## CITY OF MERCER ISLAND

WFC21-036 Review

January 4, 2022

RE: WCF21-036, 8215 SE 78<sup>th</sup> St

SHEET TITLE: **SITE PLAN**

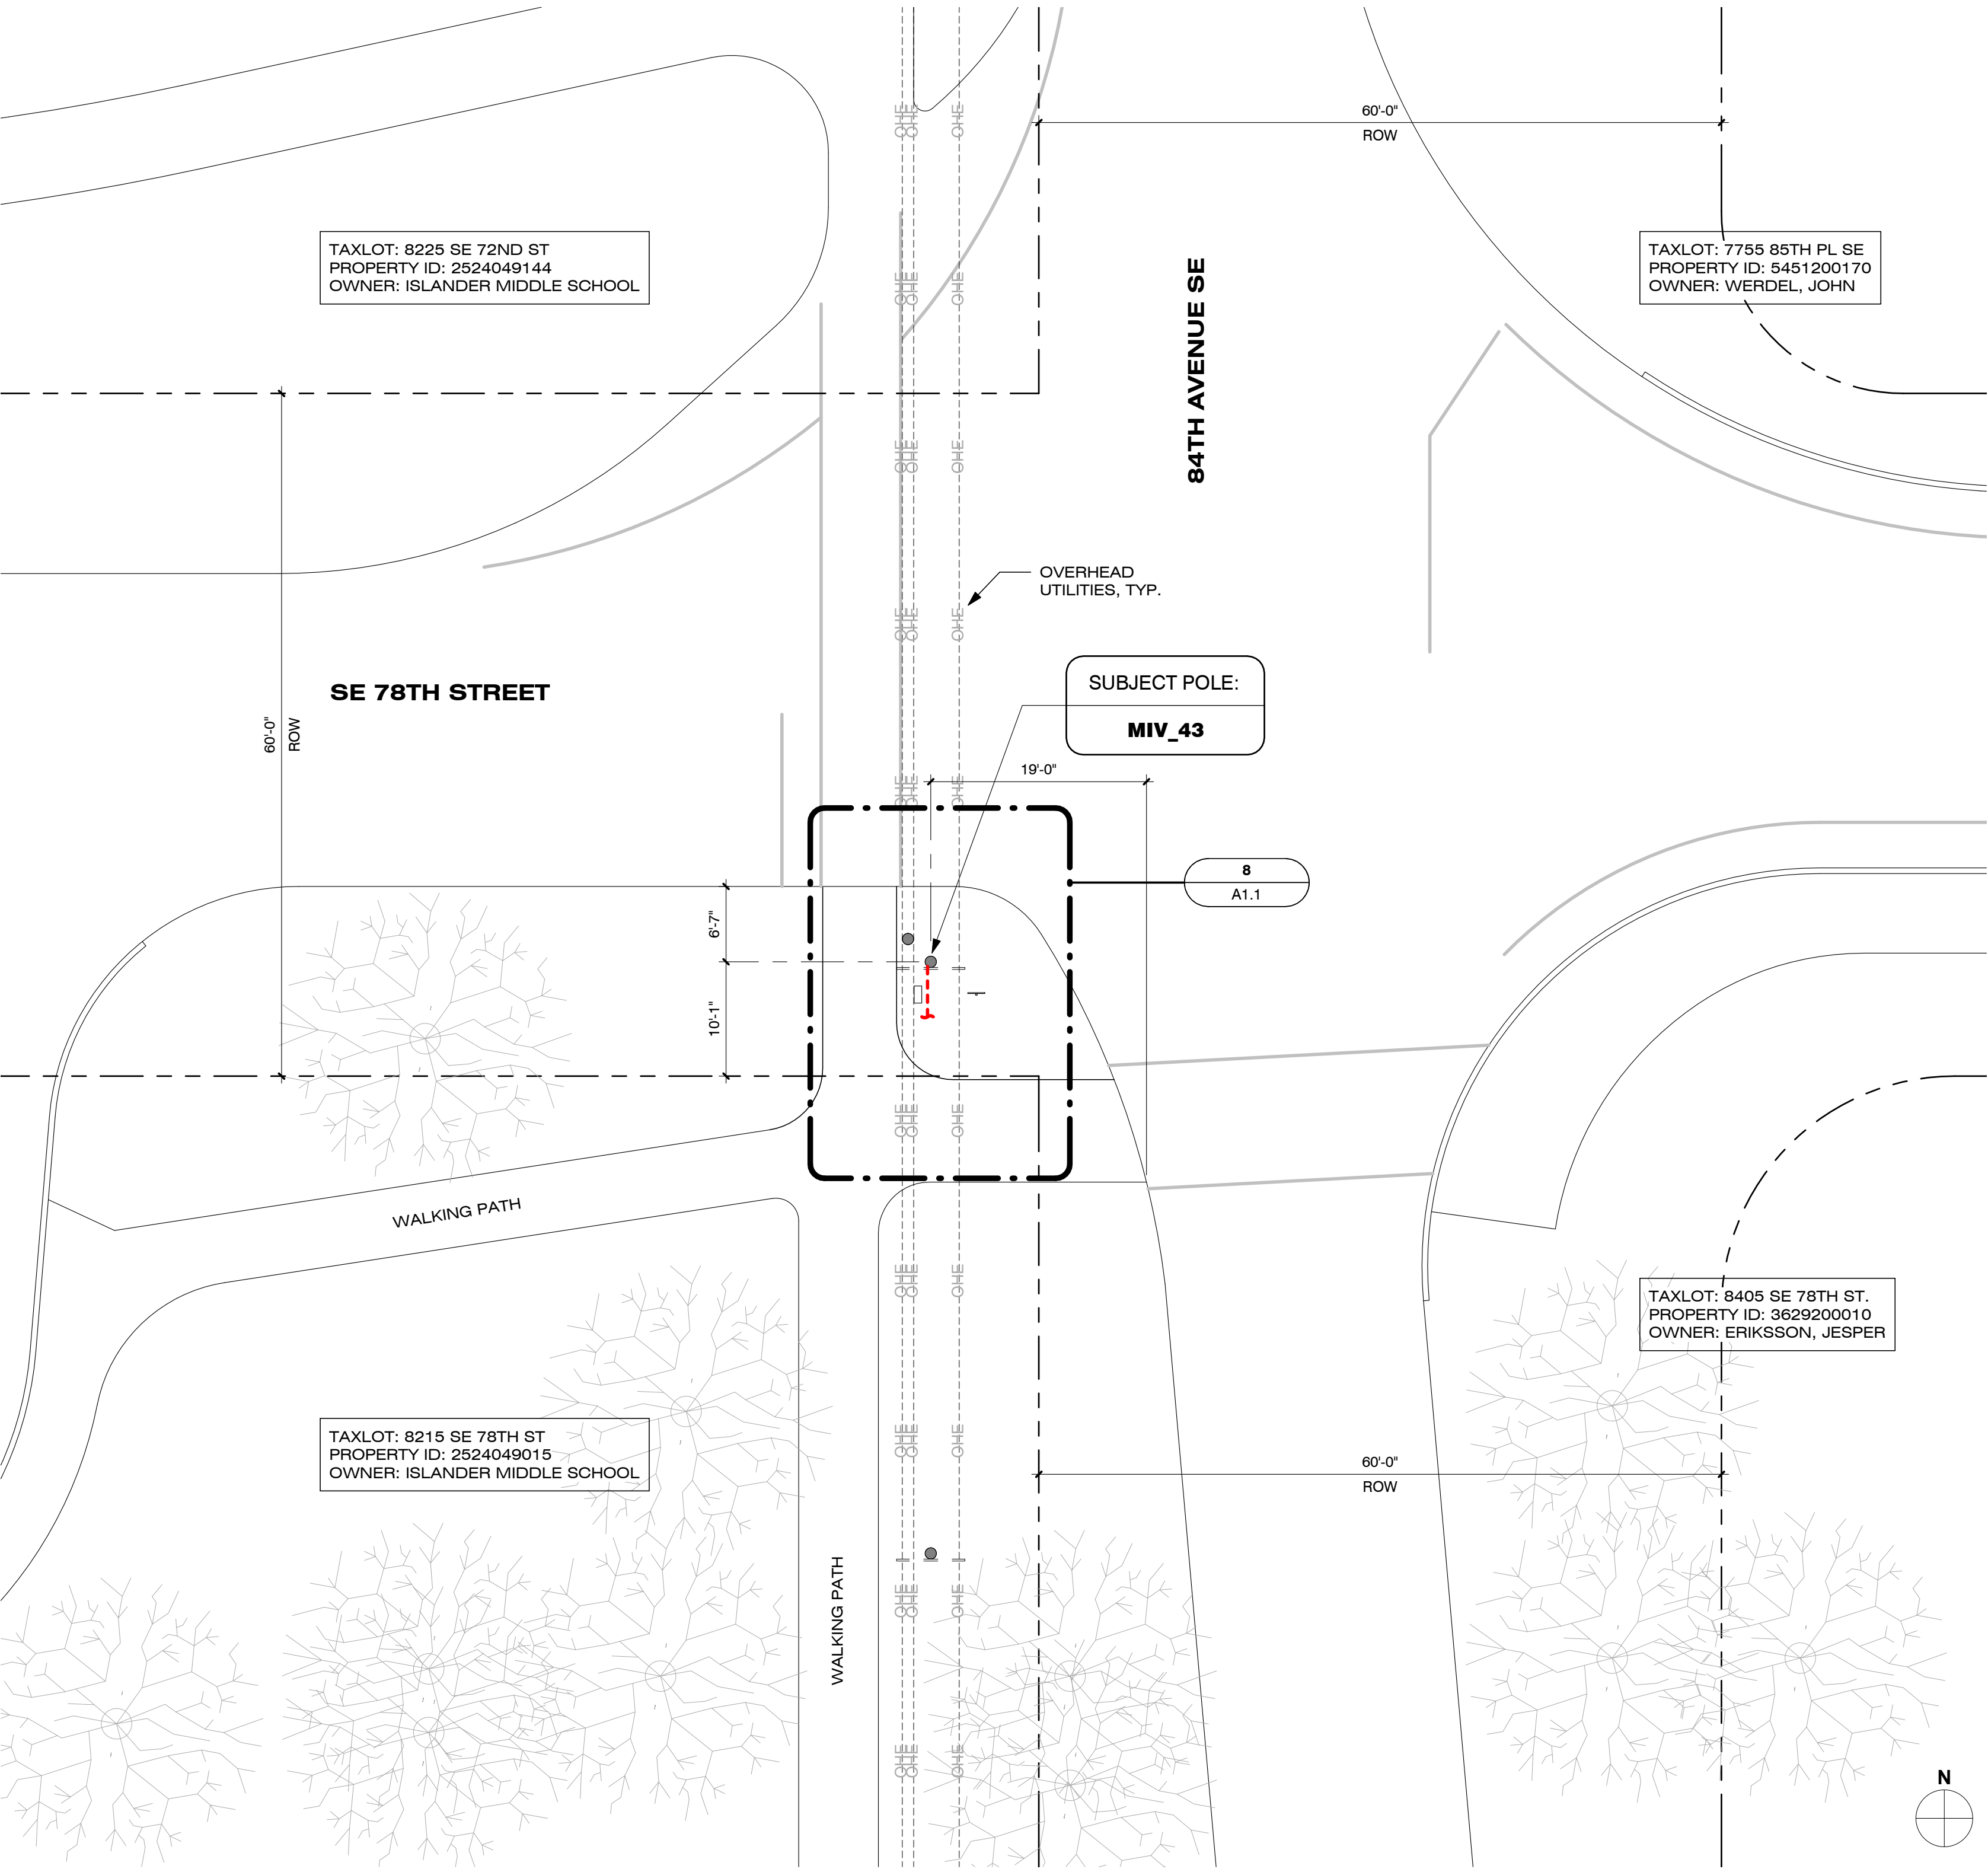
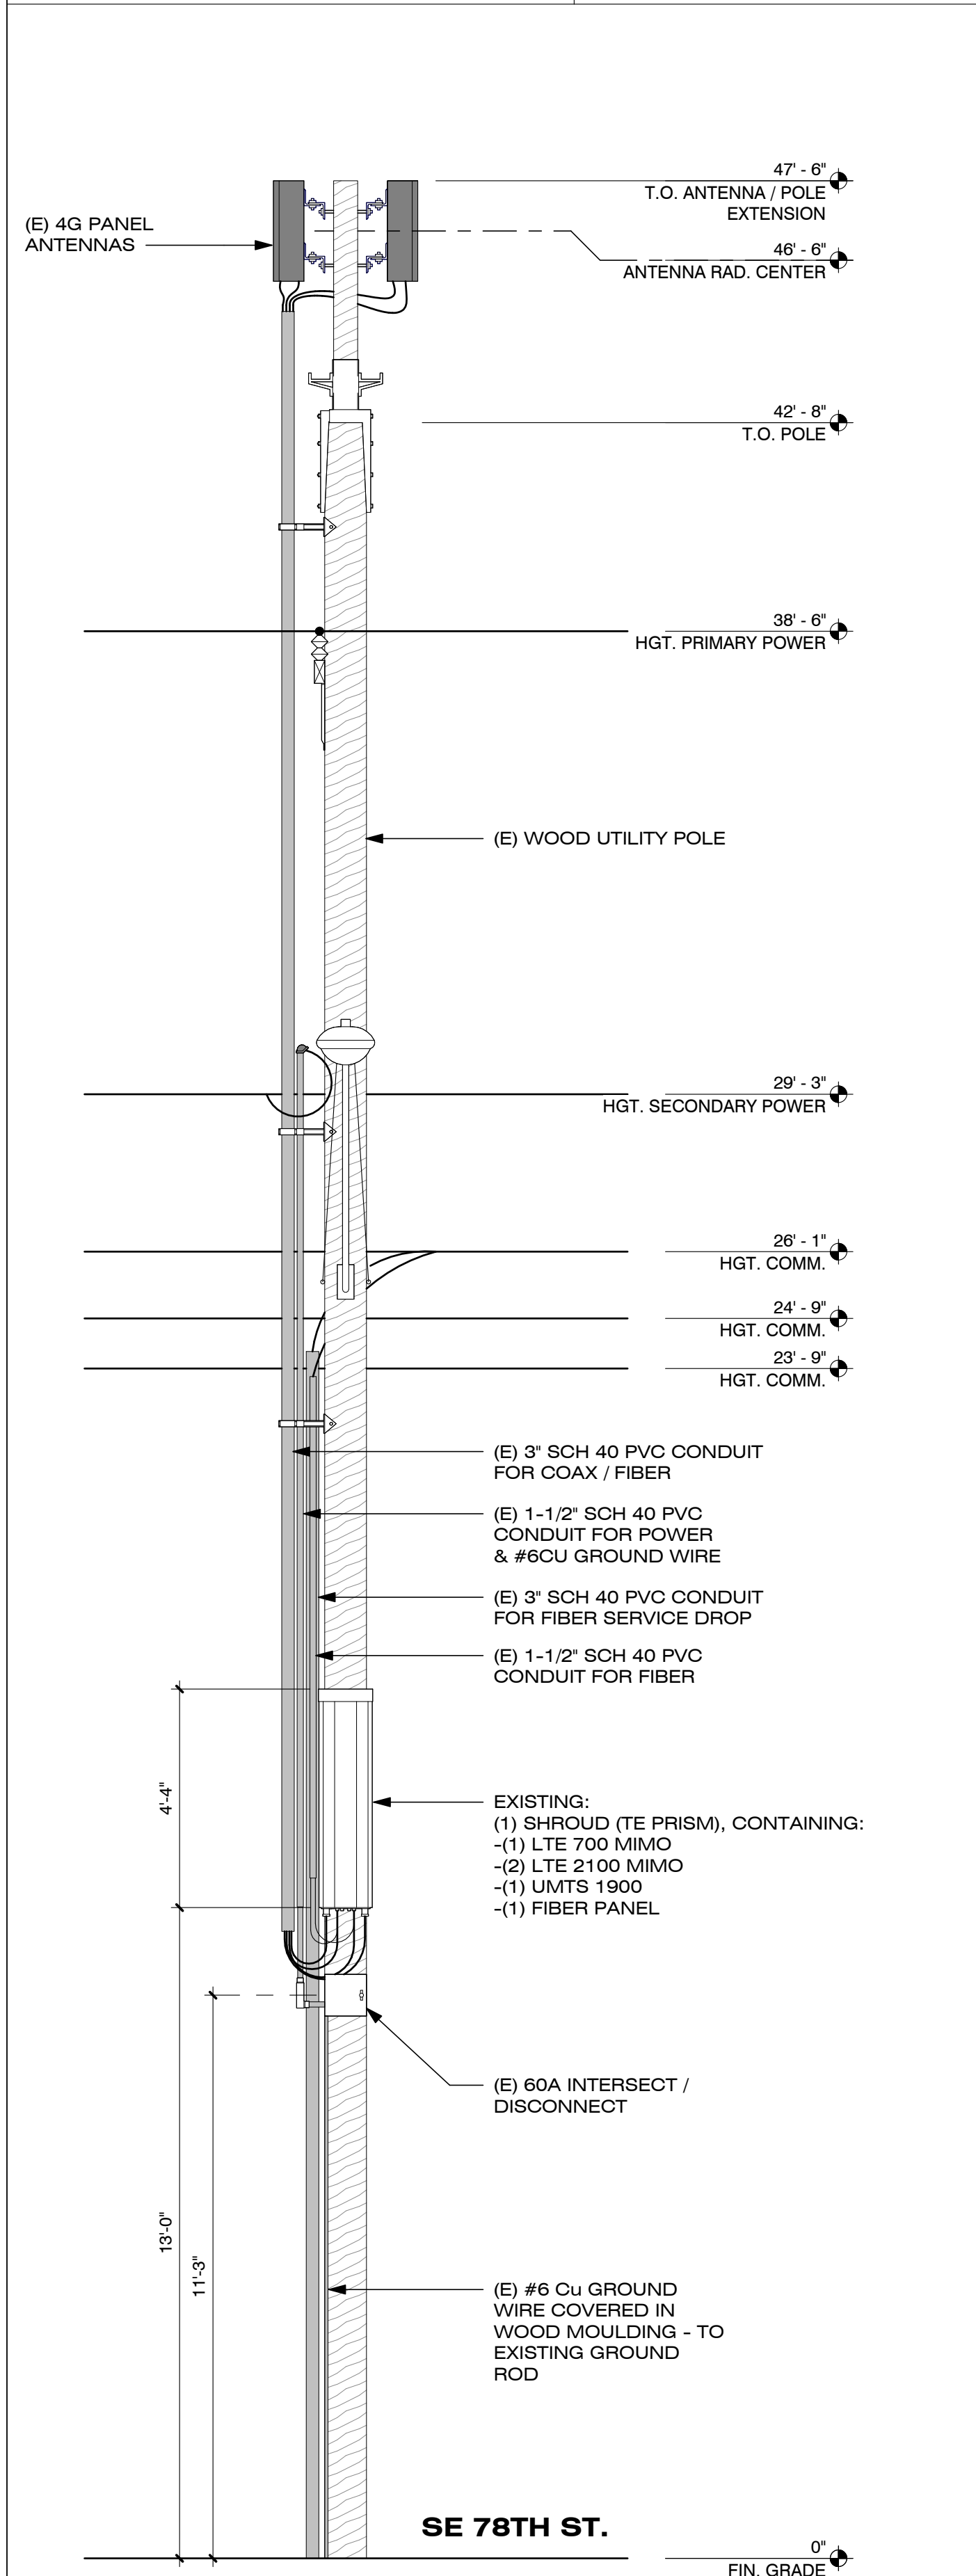
2. MICC 19.06.075(A)(1) states that ground-mounted equipment in the rights-of-way is prohibited unless such facilities are placed underground or the applicant can demonstrate that pole-mounted or underground equipment is infeasible. If ground-mounted equipment is necessary, then the applicant shall submit a concealment plan pursuant to MICC 19.06.075(G). In the new application for a modification to an existing small cell facility, please revise the location of the equipment cabinet so it is not ground mounted or provide a concealment plan for the cabinet consistent with MICC 19.06.075(G).
